From: Laura Gibbons <Laura.Gibbons@arun.gov.uk>
Sent: 21 September 2021 11:49
To: Planning.Responses <Planning.Responses@arun.gov.uk>
Cc: Michael Eastham <Michael.Eastham@arun.gov.uk>
Subject: RE: Planning Consultation on: A/188/21/DOC

Engineers Comments Regarding Surface Water Drainage

Registered: 3rd September 2021
Site Address: Land at Dappers Lane Angmering Littlehampton
Description of Works: Approval of details reserved by condition imposed under ref A/76/20/PL relating to Condition Nos 17 - existing & proposed ground levels, 18 - surface water drainage, 19 - maintenance & management of surface water drainage, 21 - discharge flows to watercourses and 22 - foul drainage system

Drawing: 20079 - 211 C

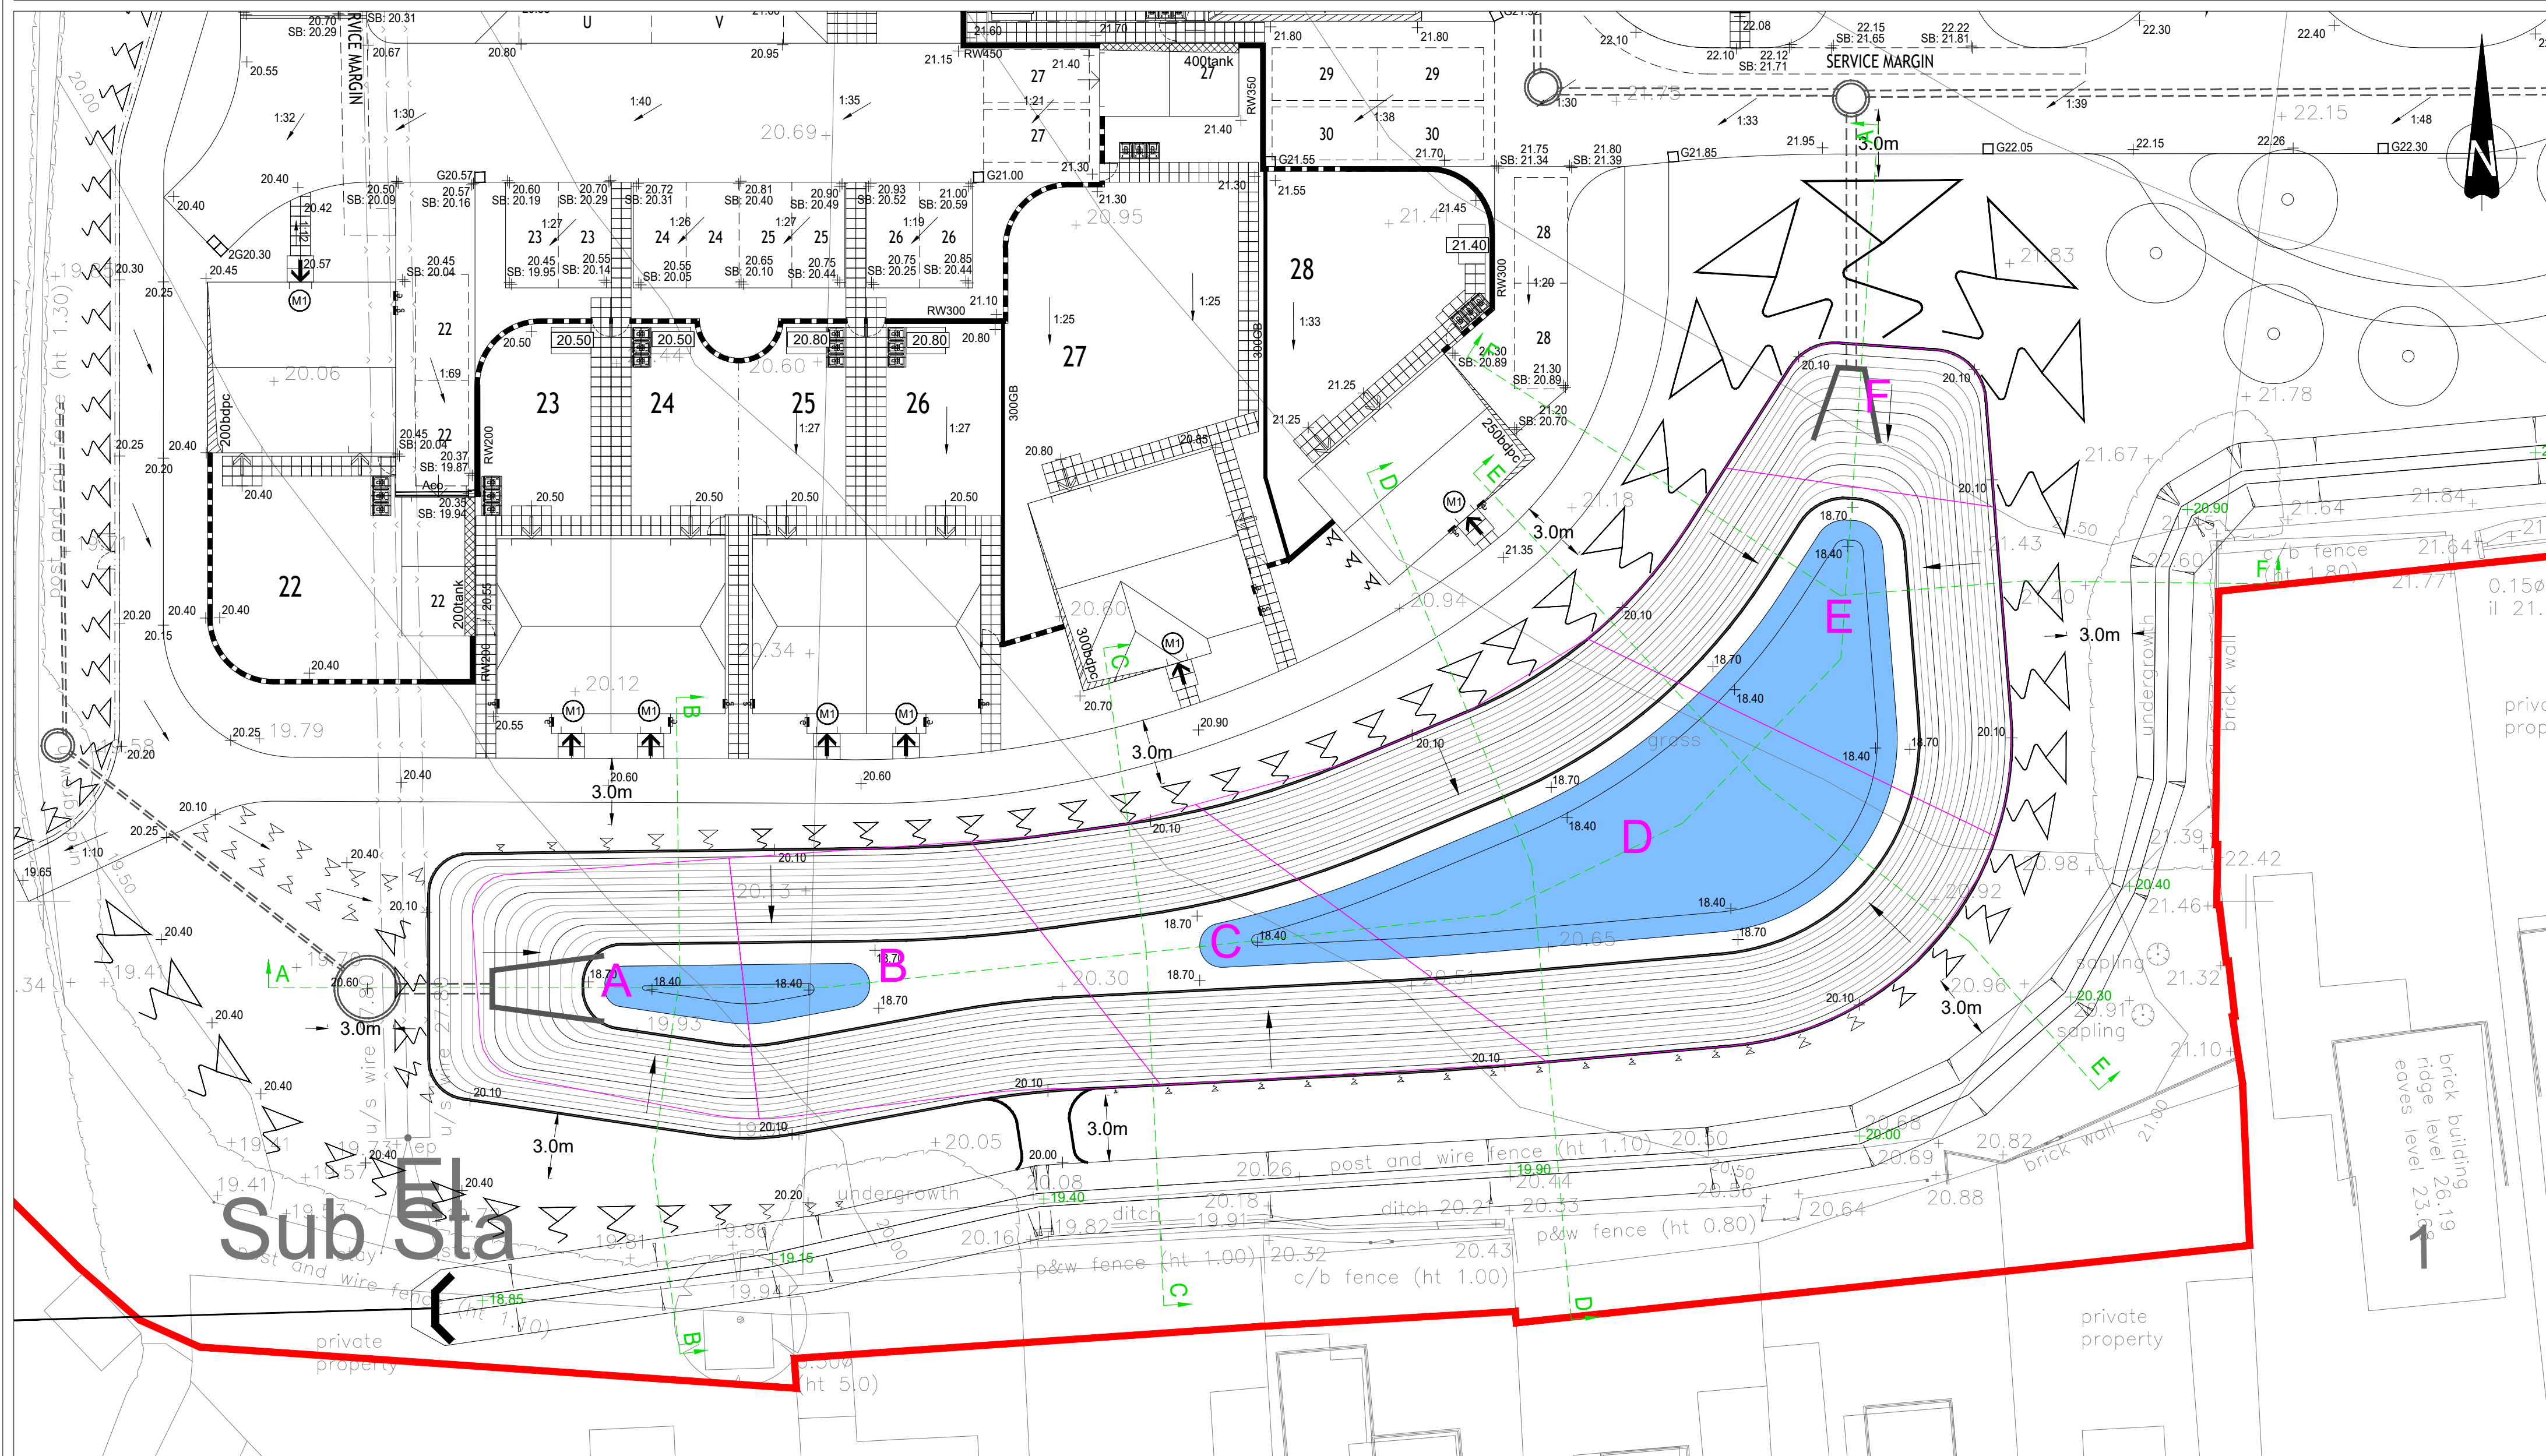
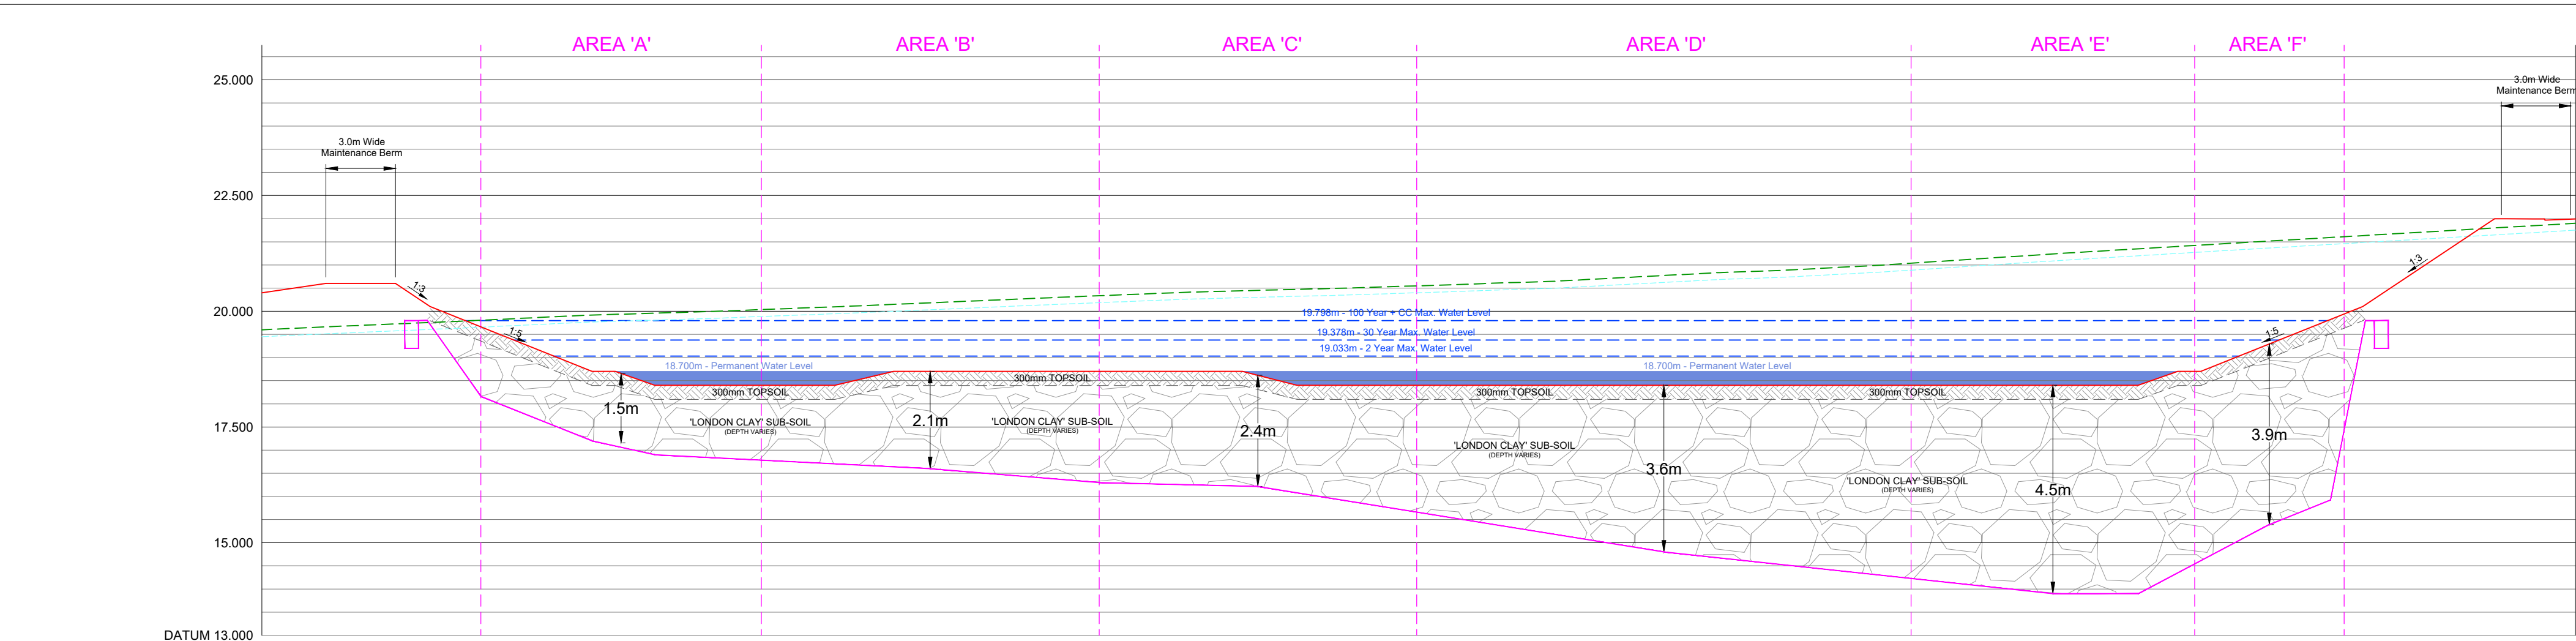
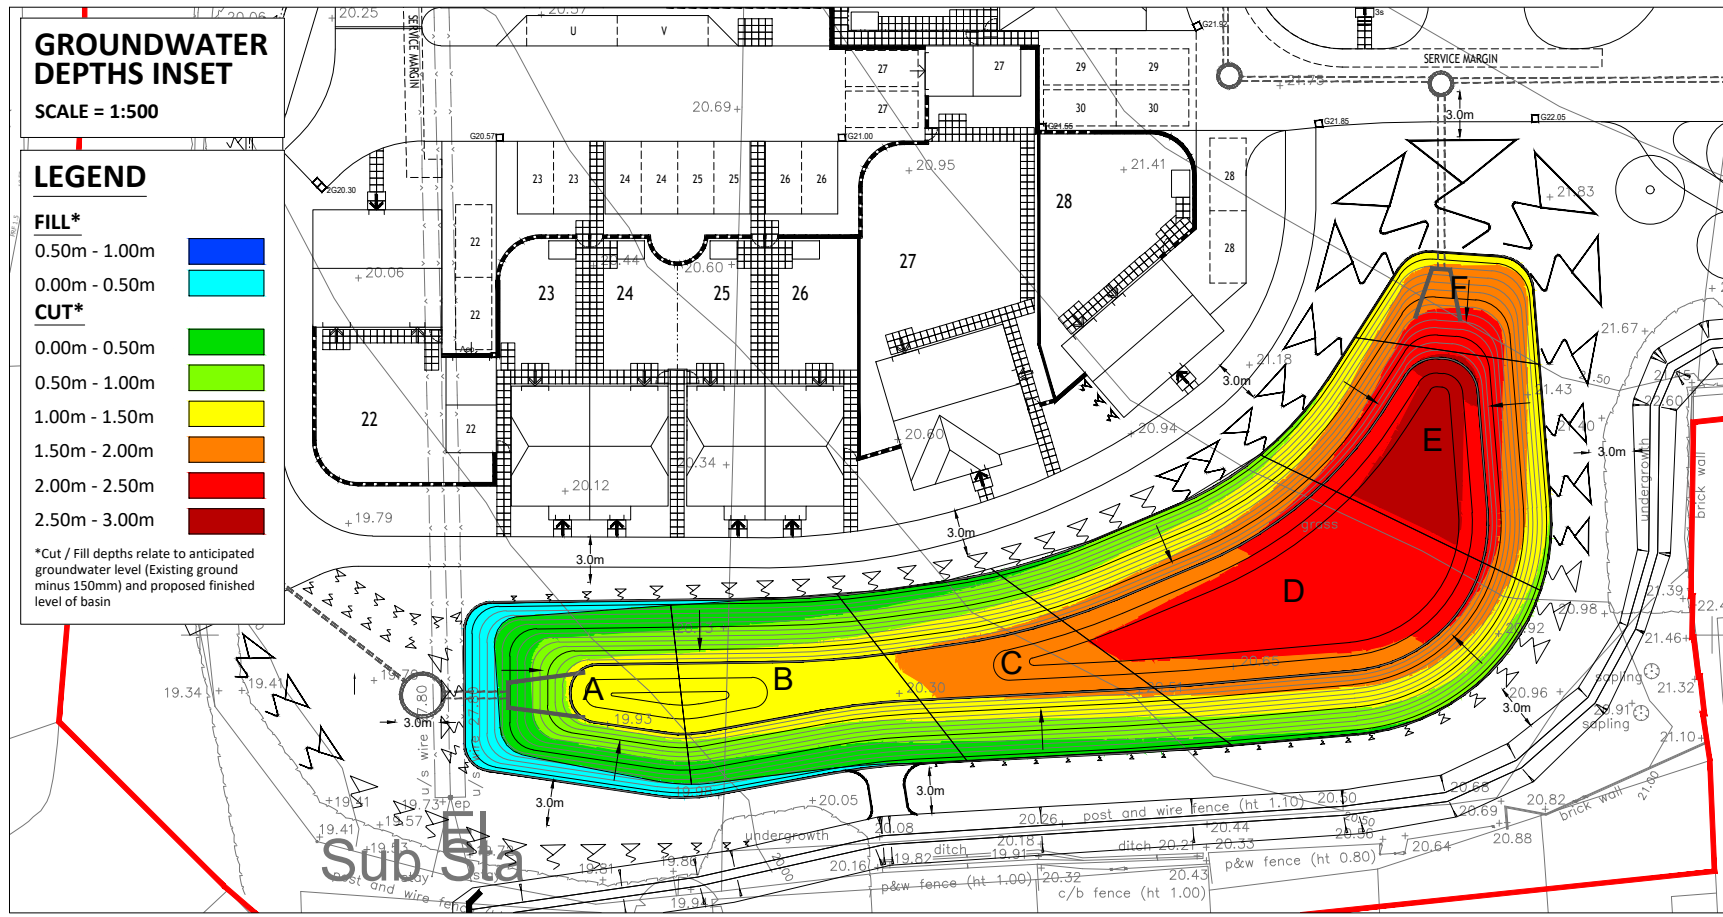
No flotation calculations have been provided, a further statement from a geotechnical company has been provided, this does not alter our previous requests for features to be lined and for flotation calculations to be provided. The

majority of Angmering sites in this area have groundwater at around 1m depth or shallower, design must demonstrate that groundwater will be kept out of attenuation features now and for the lifetime of development. BGC 30/08/21 - Attenuation Basin floatation calculations illustrated on drawing; 20079/211. Cellular Storage floatation calculations illustrated on word document; 20079 – Cellular Storage Floatation Calculations – 2021.08.04.

Calculations should apply a factor of 0.9 to resisting forces, and a factor of 1.1 to destabilising forces. Furthermore the concrete cover slab to crates will also displace groundwater, this has not been accounted for in calculations and design.

It is unclear how it will be possible to excavate 4.5m below the base of the attenuation basin and line it with an impermeable liner. Groundwater will make construction exceptionally difficult, if not impossible. The proximity of the basin to the adjacent watercourse will also prevent adequate batter, and will necessitate significant temporary works to stabilise excavations. Cost of replacement of liner at end of design life is an unfair burden upon residents. Also unclear how it will be possible to construct the basin with such varying liner depth accurately.

REF 20079 - CC28

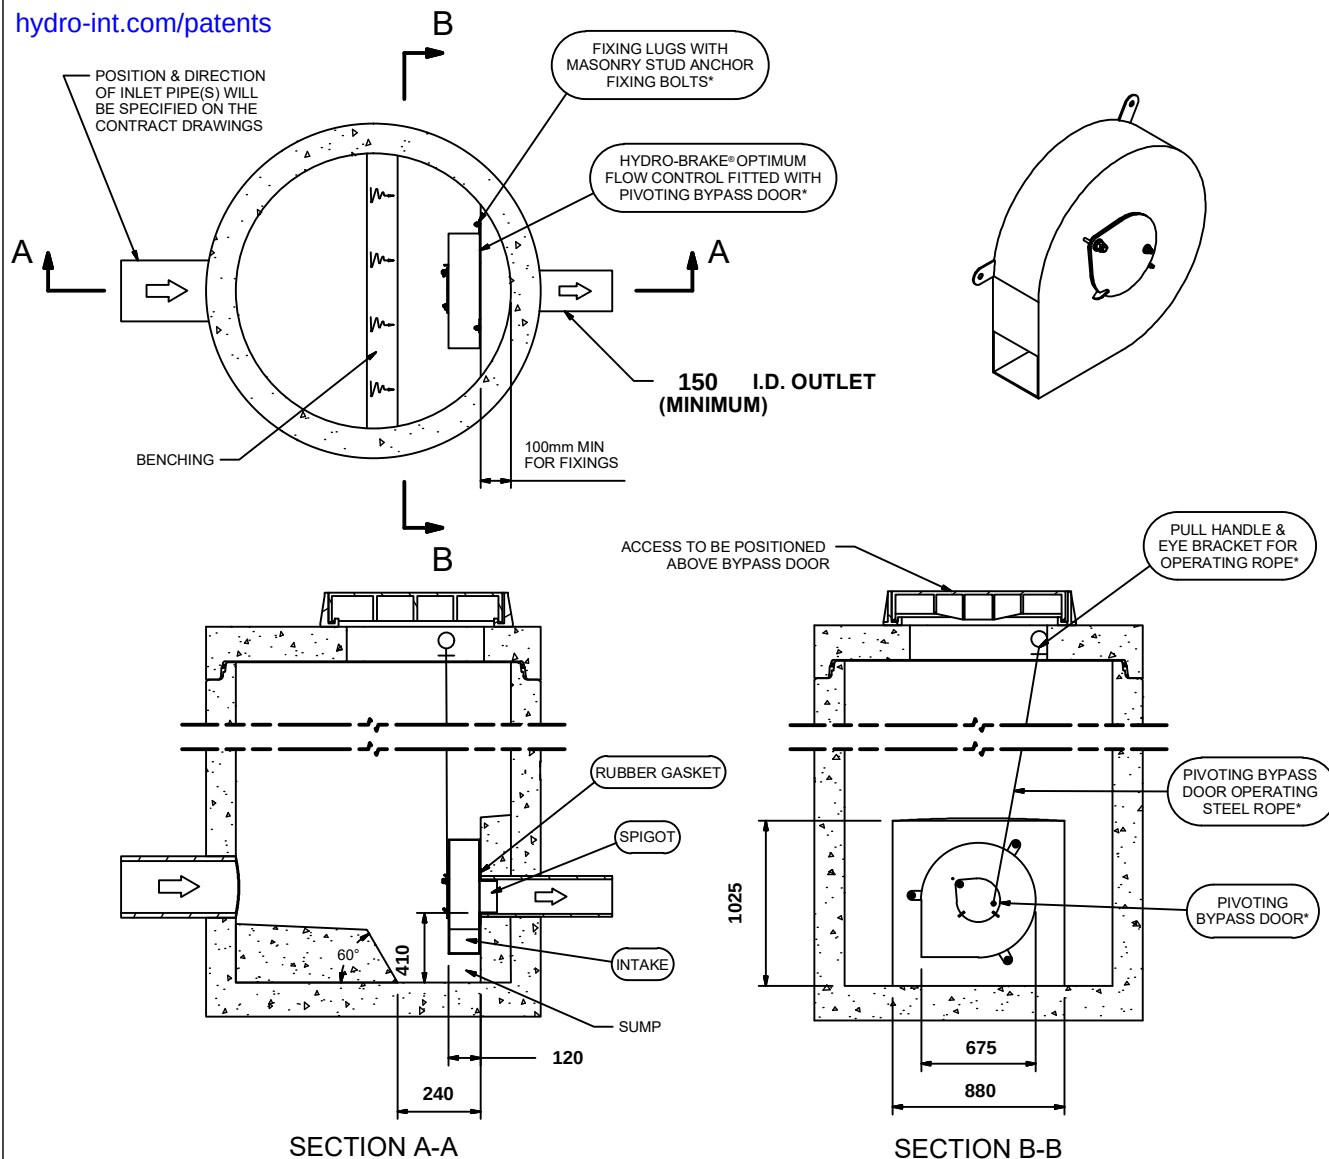
Overflow levels at CC12 and CC28 appear to be below 100 year plus 40% cc water level.
